Please ask for: Sian Eggington
Email: sian.eggington@terraquest.co.uk
Telephone: 0121 234 1390
Our Ref: A/28/22/HH
Your Ref:
Date: 23rd February 2022

Application for Planning Permission for Works or Extension to a Dwelling

Development: Single storey mono pitch roofed extension. Single Storey front extension to lounge with shower room, attached garage conversion
Location: 27 Beech View Angmering BN16 4DE

27 Beech View, Arun District Council
Existing 1st floor plan + back/corridor plan 27/01/23
REV A

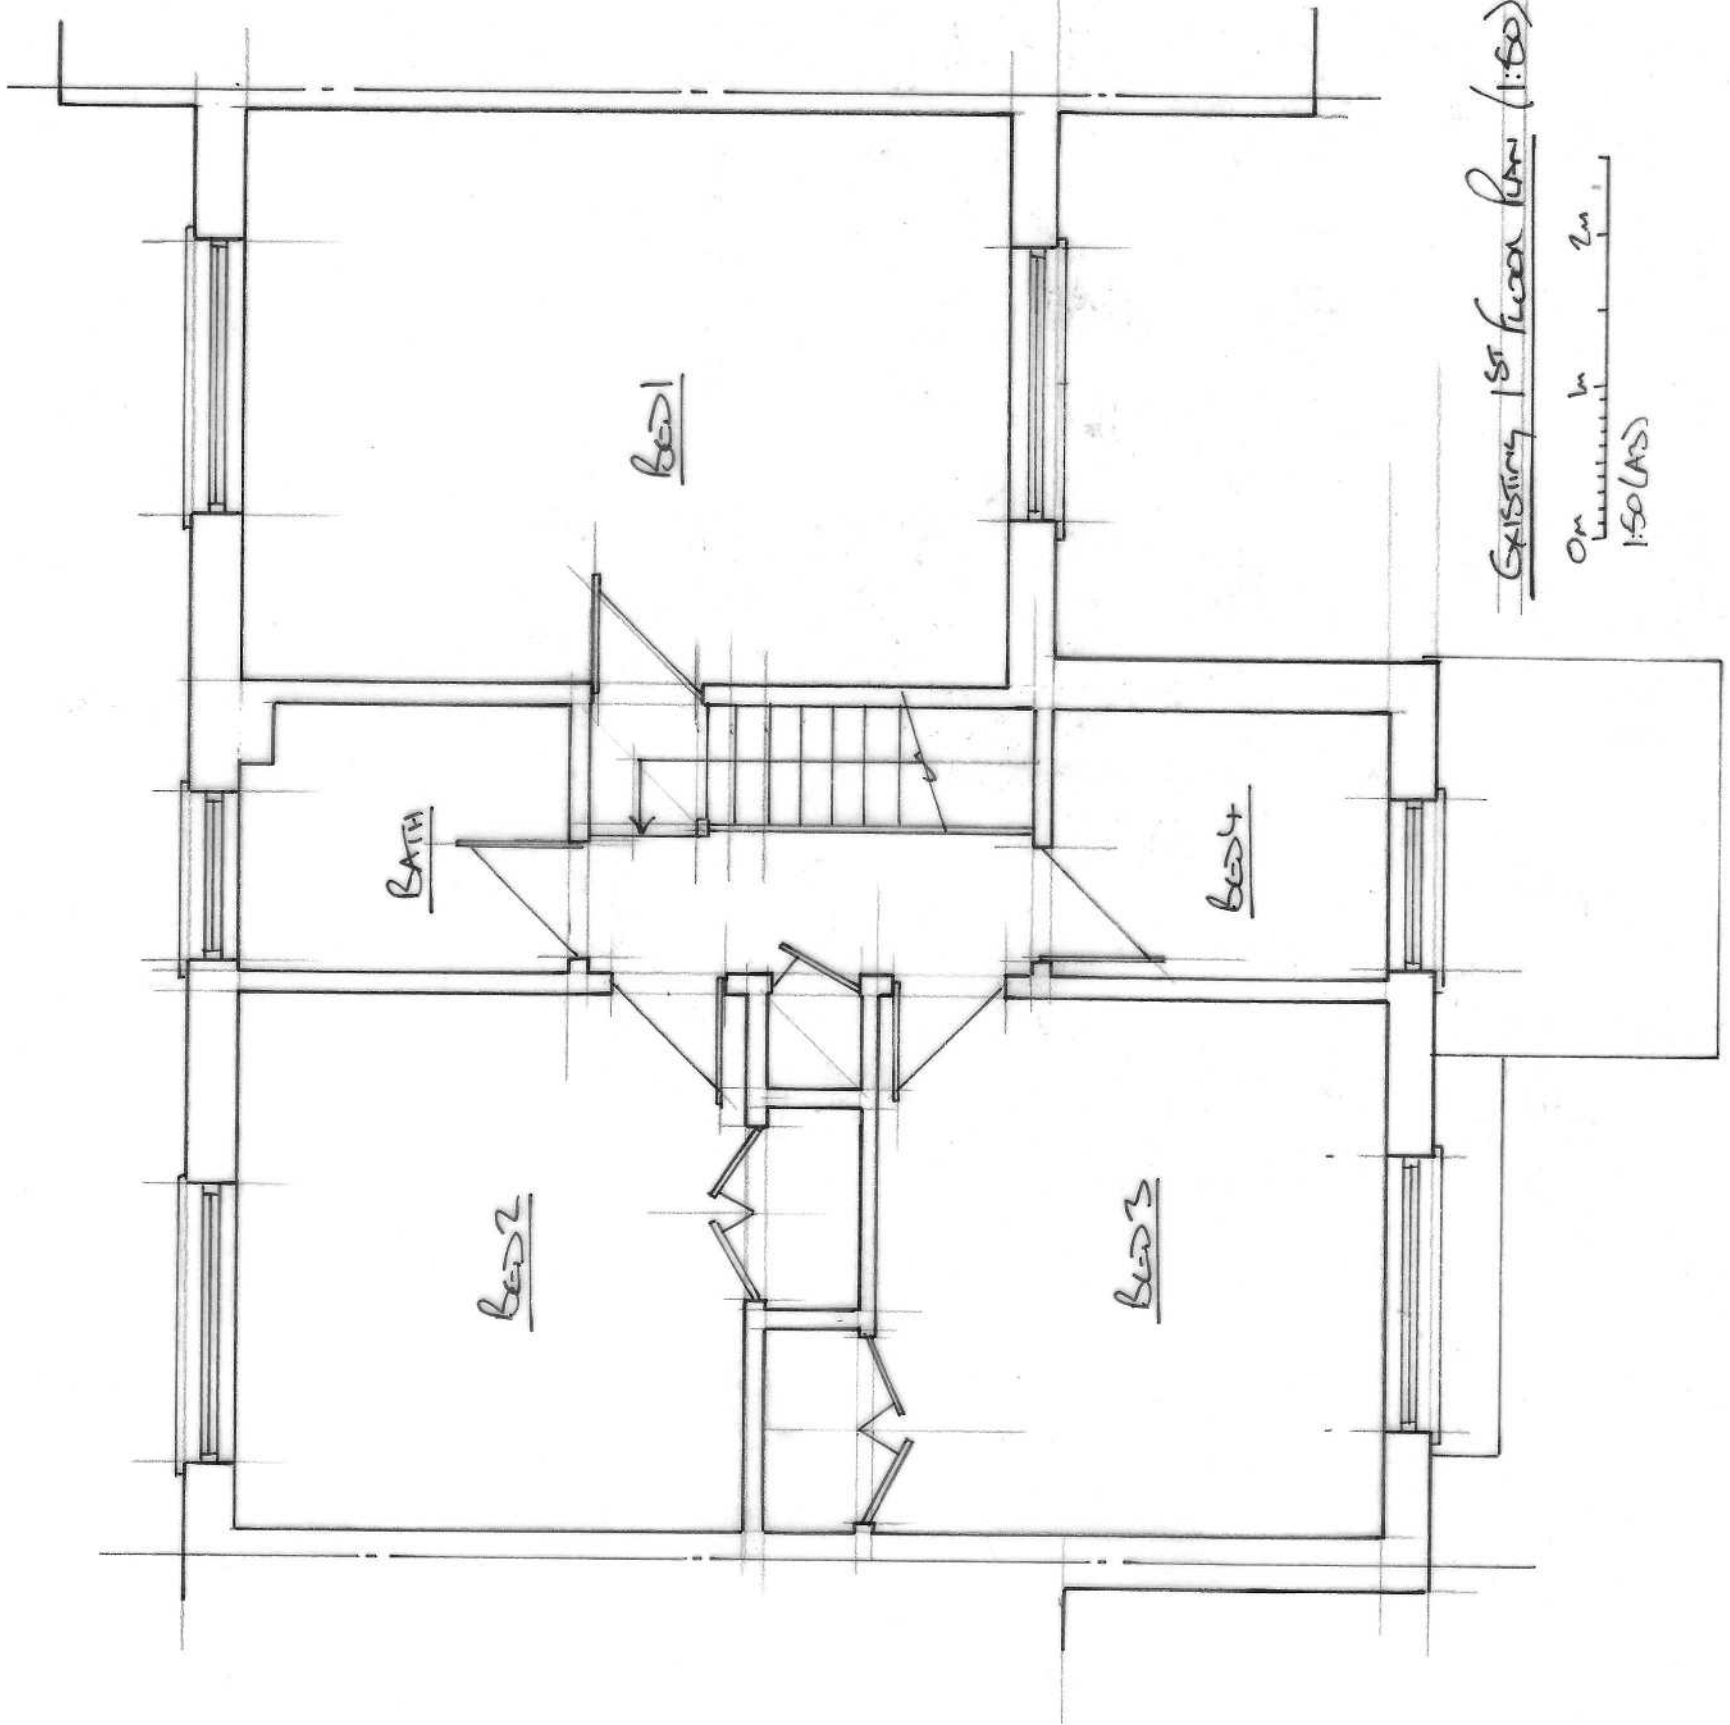
Dimensions: You are required to include dimensions on the block plan from the proposed extension(s) to ALL site boundaries. Please amend.
